Our Ref: EP/65/26/DOC

Approval of details reserved by condition imposed under EP/121/25/PL relating to conditions 3 grease trap separator, 4 extractor maintenance schedule, 5 noise scheme and 6 acoustic report.

19-21 Sea Road East Preston BN16 1JN

Arun District Council have decided to **REFUSE details reserved by condition for the following reasons:**

Figure 6. North Elevation - Updated Fan Location.

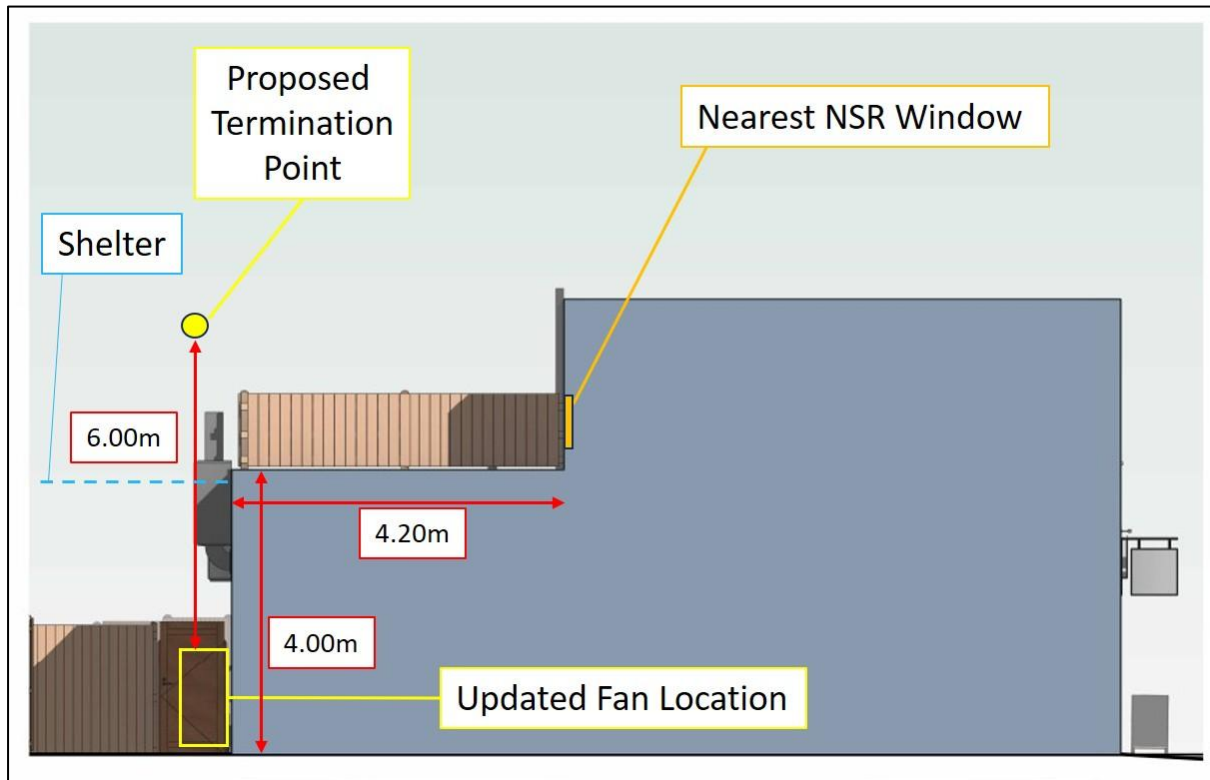
Condition 4 requires details of the proposed extraction and odour treatment scheme and a maintenance schedule for that scheme. The submitted information does not provide sufficient details of the proposed odour control measures and fails to demonstrate how fumes and cooking odours will be effectively treated before discharged to the atmosphere. This matter is particularly important given that

the proposed kitchen extract termination point appears to be directly in line with windows of the flat above the premises. In such circumstances, we would normally expect the applicant to undertake an odour impact assessment in accordance with the current EMAQ guidance to demonstrate that the proposed extraction and filtration system will not adversely affect neighbouring residential amenity.
